BOTLEY WEST SOLAR FARM

OXFORDSHIRE HOST AUTHORITIES RESPONSES FOR DEADLINE 5 | FRIDAY 12 SEPTEMBER 2025

The purpose of this submission is to provide written confirmation of the OHA’s comments and response on documents submitted at Deadline 4 (**D4**), responses to Second Written Questions (**ExQ2**). The written comments provided below do not prejudice the OHA’s ability to make further comments on these matters.

Illustrative Masterplan
Figure 5.3A: Cable Corridor Option A

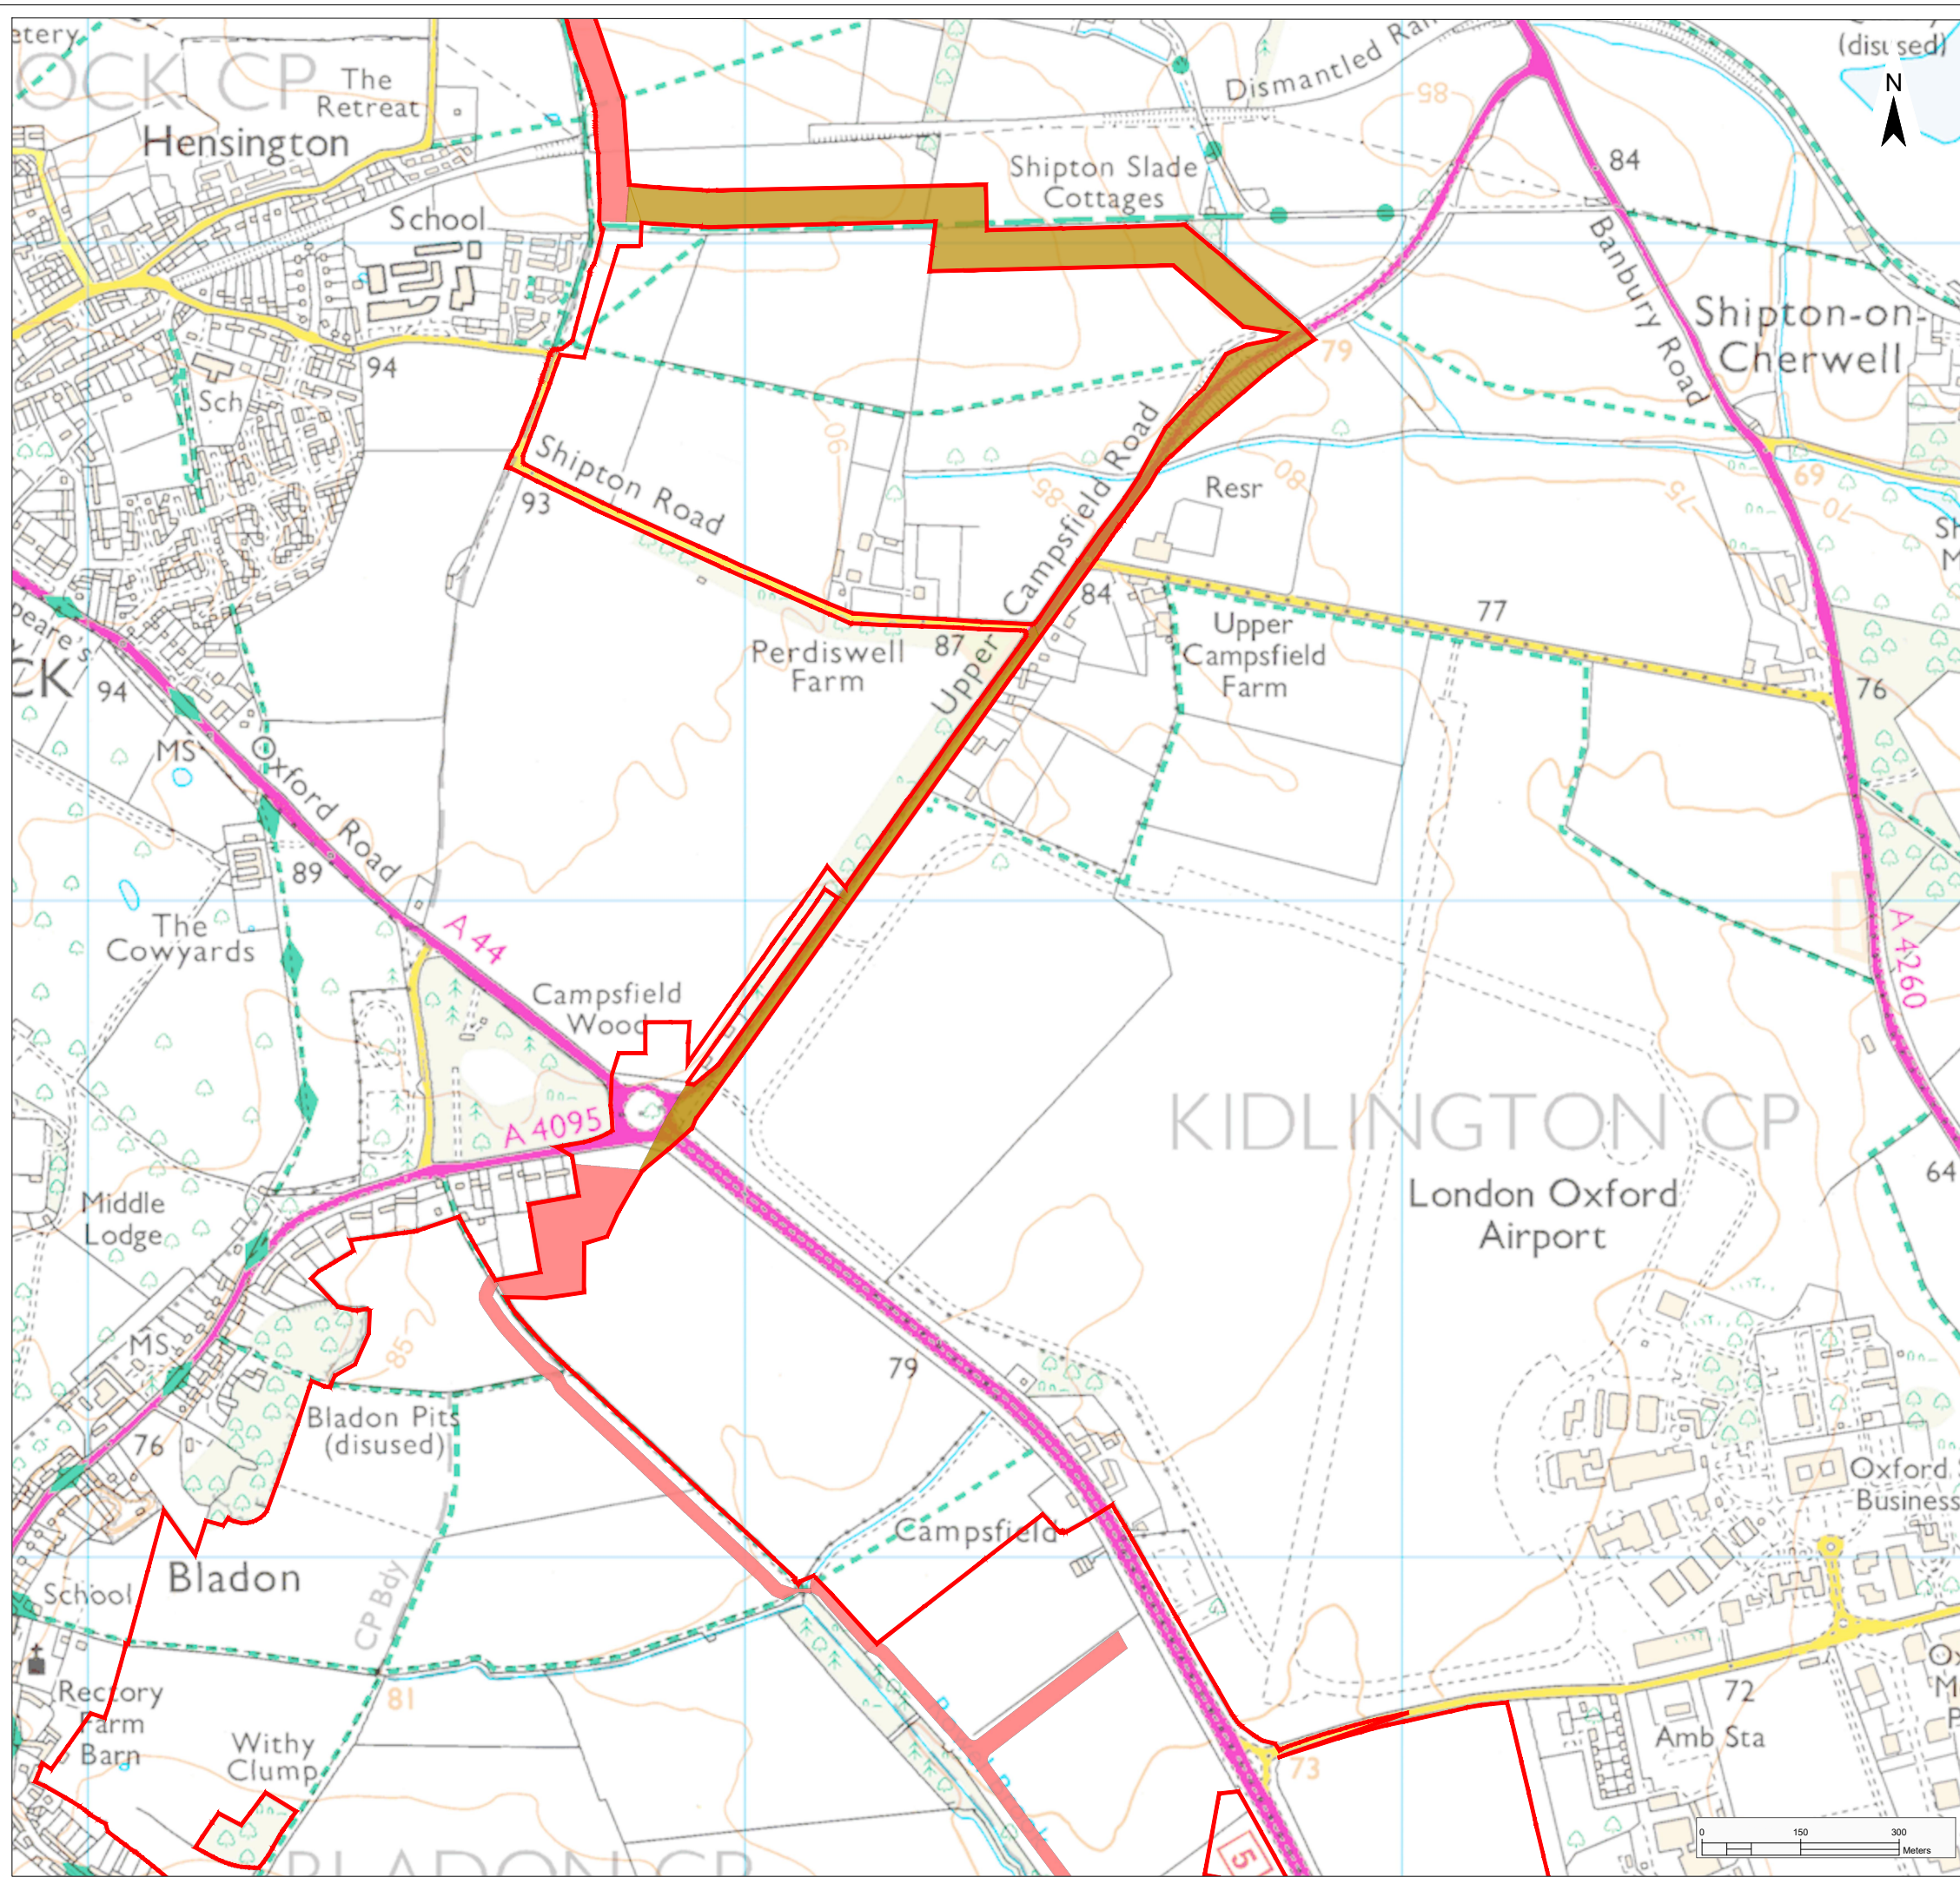
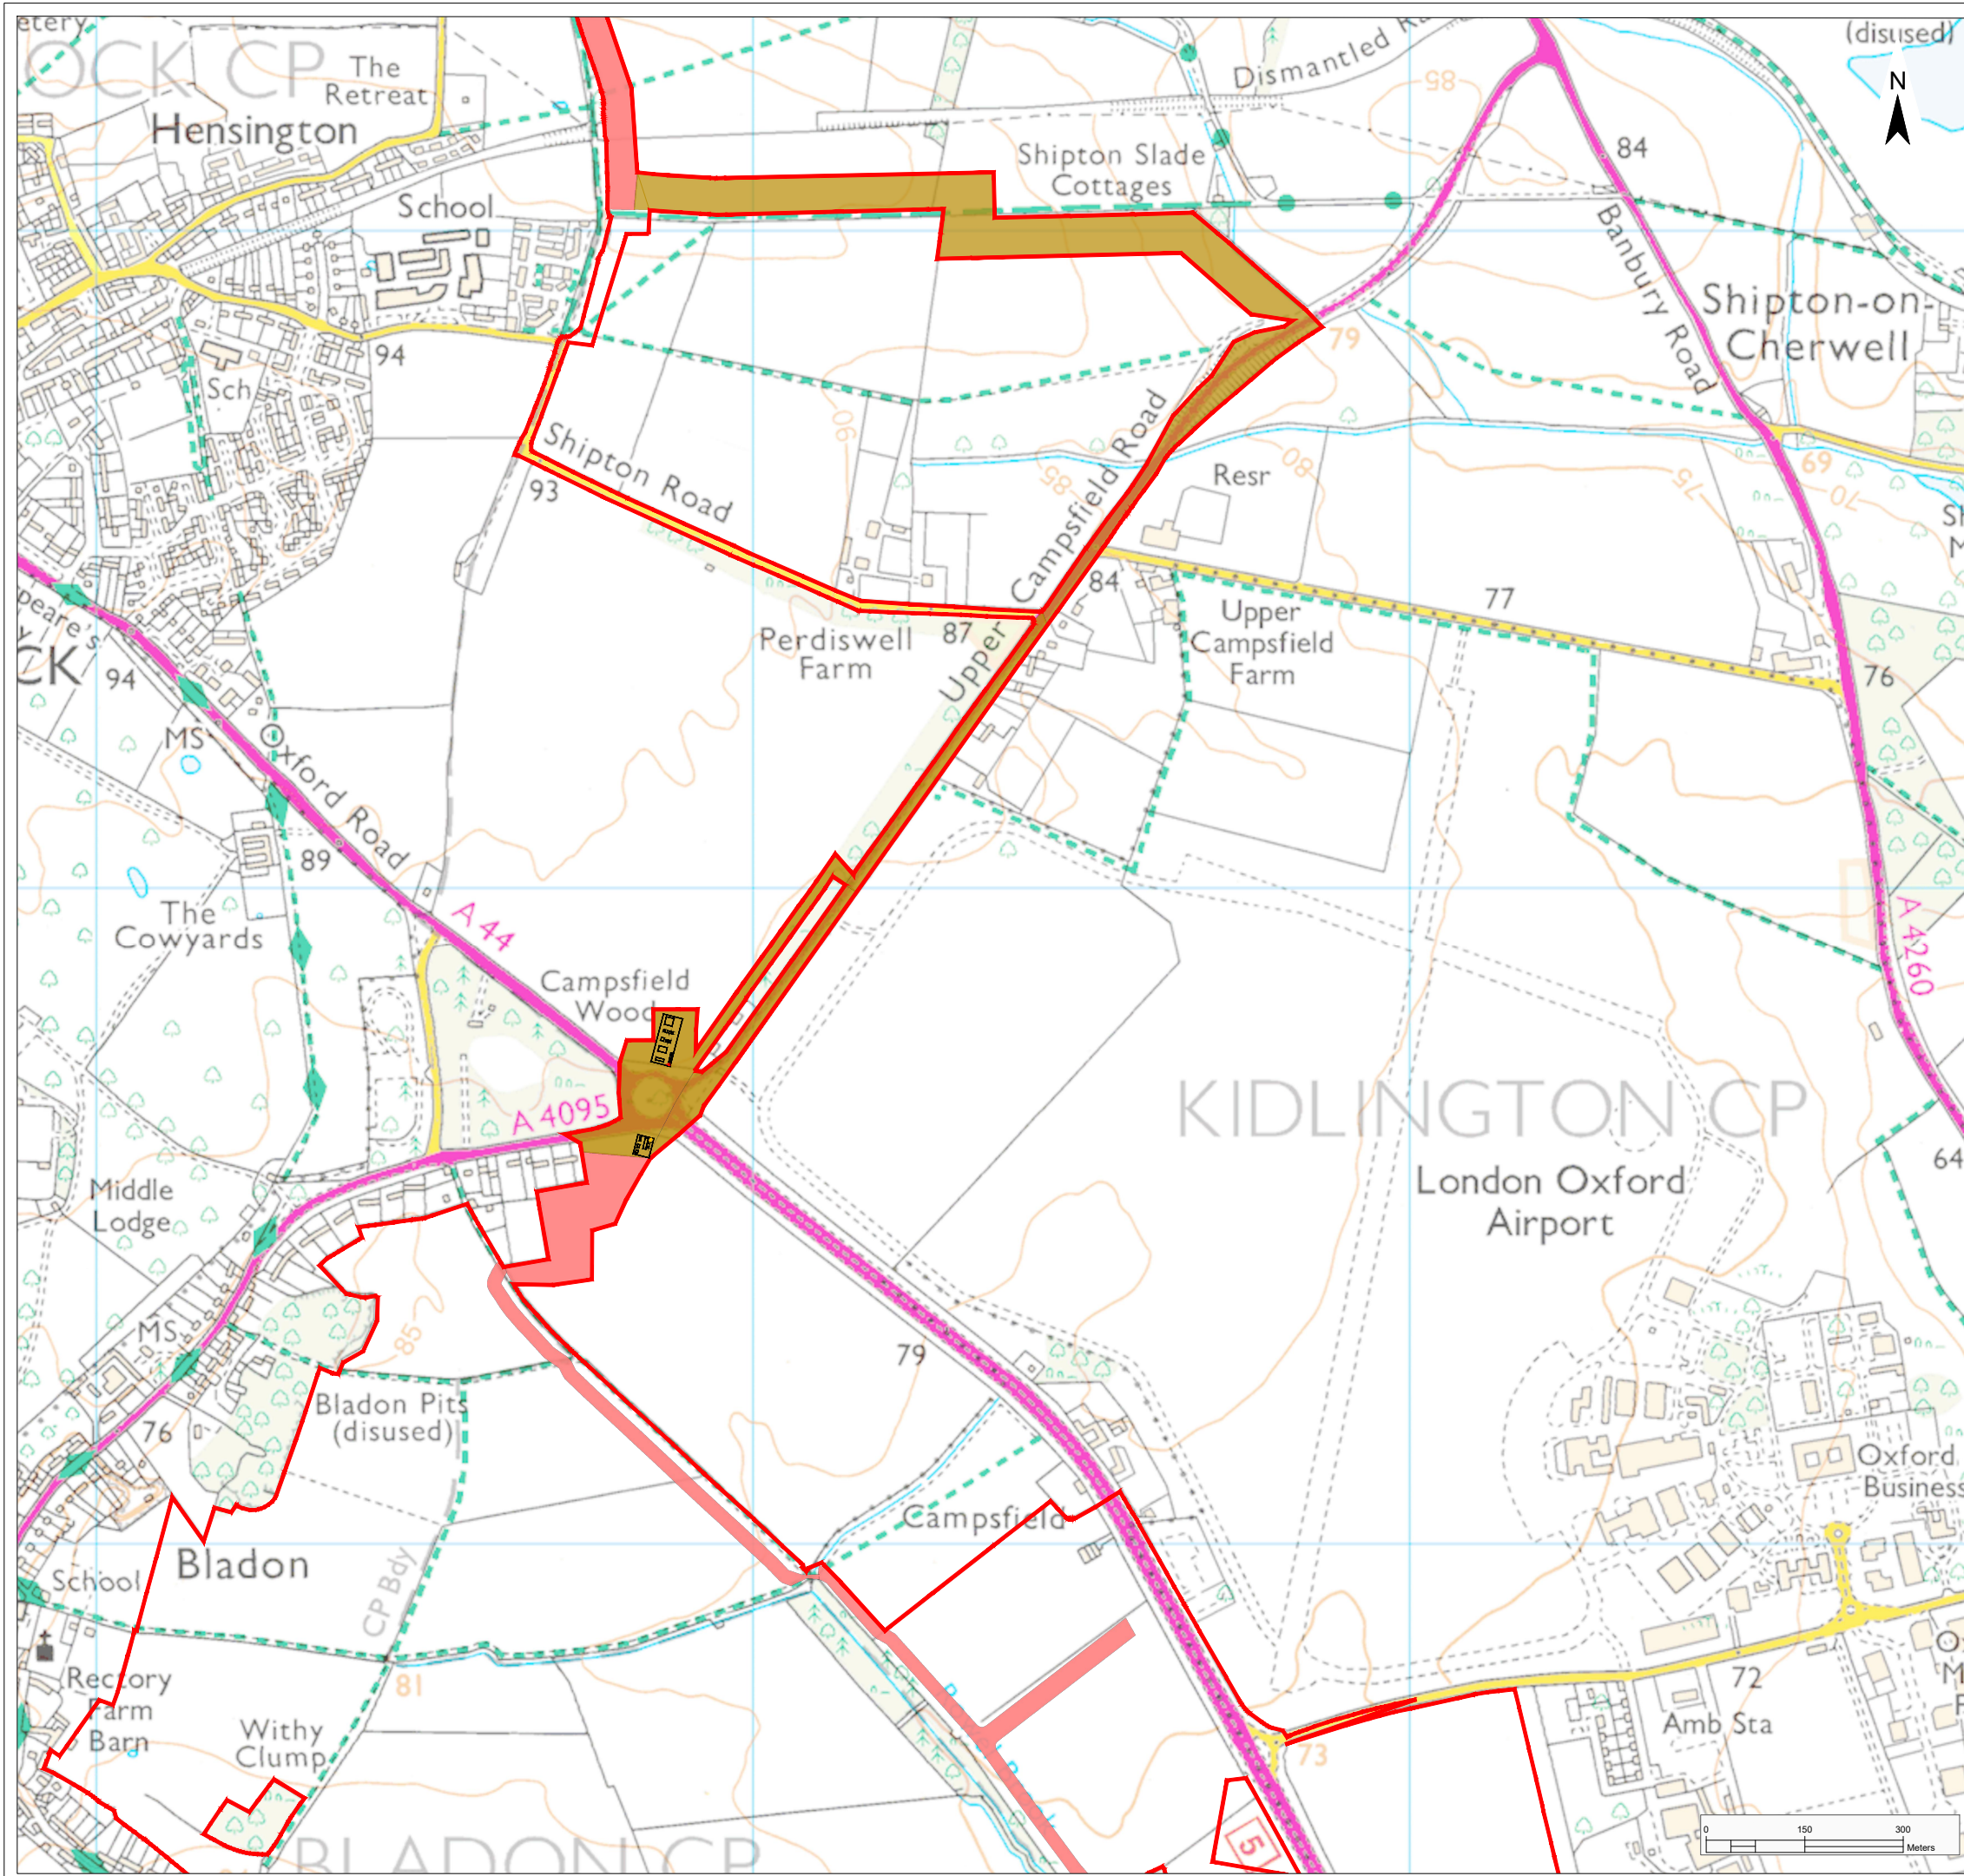
<p>At 2.3.5 of the report, it states that ‘<i>This cable corridor follows the eastern perimeter of Bladon Heath, avoiding direct woodland intrusion but passing close to several ecological and arboricultural features, including mature trees, hedgerows, and a veteran tree protected under BS 5837 and the NPPF. To avoid trenching within the tree’s root protection zone (RPZ), a Horizontal Directional Drilling (HDD) section may be required; the final decision on HDD use will be made in consultation with OCC.</i></p> <p>However, without the detailed arboricultural survey and an updated detailed arboricultural impact assessment, an accurate assessment of the route of this cabling on the arboricultural features including a veteran tree cannot be made.</p> <p>The applicant is reminded of the following standing advice: ‘For ancient or veteran trees (including those on the woodland boundary), the buffer zone should be at least 15 times larger than the diameter of the tree. The buffer zone should be 5 metres from the edge of the tree’s canopy if that area is larger than 15 times the tree’s diameter. This will create a minimum root protection area’ (https://www.gov.uk/guidance/ancient-woodland-ancient-trees-and-veteran-trees-advice-for-making-planning-decisions#avoid-impacts-reduce-mitigate-impacts-and-compensate-as-a-last-resort).</p> <p>OCAS comments on cable routes</p> <p>Cable Optionality Area 1 - Northern Site between the Oxfordshire Way, and B4027, south east of Wootton</p> <p>The area proposed by these two options were not assessed by the archaeological evaluations of the proposal. There are however located in an area of considerable archaeological interest with both options running alongside the Witney Ridgeway, recorded as Grundy’s Road 3 and called Heh Street in the Shipton on Cherwell charted od AD 1005. Both options also cross the known line of Akeman Street, the Roman Road from Alchester to Cirencester. In addition, two parallel linear features have been recorded from aerial photographs from 1961 200m NE of these proposed cable routes. These features have been recorded as a possible Neolithic Cursus monument although a</p>

<p>re-examination of the photographs does suggest they are likely to be a pre-medieval trackway, a continuation of which would cross the line of these proposed cable options.</p> <p>As such we cannot agree with the assessment in this document (EN010147) which states that no heritage assets would be affected. This area would need to be subject to further evaluation and mitigation, including preservation in situ of any significant remains as set out in the submitted overarching written scheme of investigation.</p> <p>Cable Optionality Area 2 - Area between the Northern and Central Sites on land to the east of Woodstock and in the vicinity of the Bladon roundabout on the A44</p> <p>Option 1 – This area was not subject to the archaeological evaluation and as such the archaeological potential of the site is unknown. The proposed route is however located in an area of archaeological interest and an area of prehistoric settlement has been recorded adjacent to the southern part of this option (HER PRN 28571). This route option therefore has the potential to impact archaeological features related to this settlement and to impact previously unrecorded archaeological deposits along the route.</p> <p>Option 2 – this proposed route also has the potential to impact on the area of prehistoric settlement recorded adjacent to its southern end. The section along Shipton Road also runs immediately north of archaeological features (HER PRN 28750), identified from a geophysical survey and trenched evaluation undertaken as part of a housing application which form a continuation of the scheduled Blenheim Villa (SM 35545).</p> <p>As such we cannot agree with the assessment in this document (EN010147) which states that no heritage assets would be affected. This area would need to be subject to further evaluation and mitigation, including preservation in situ of any significant remains as set out in the submitted overarching written scheme of investigation.</p>
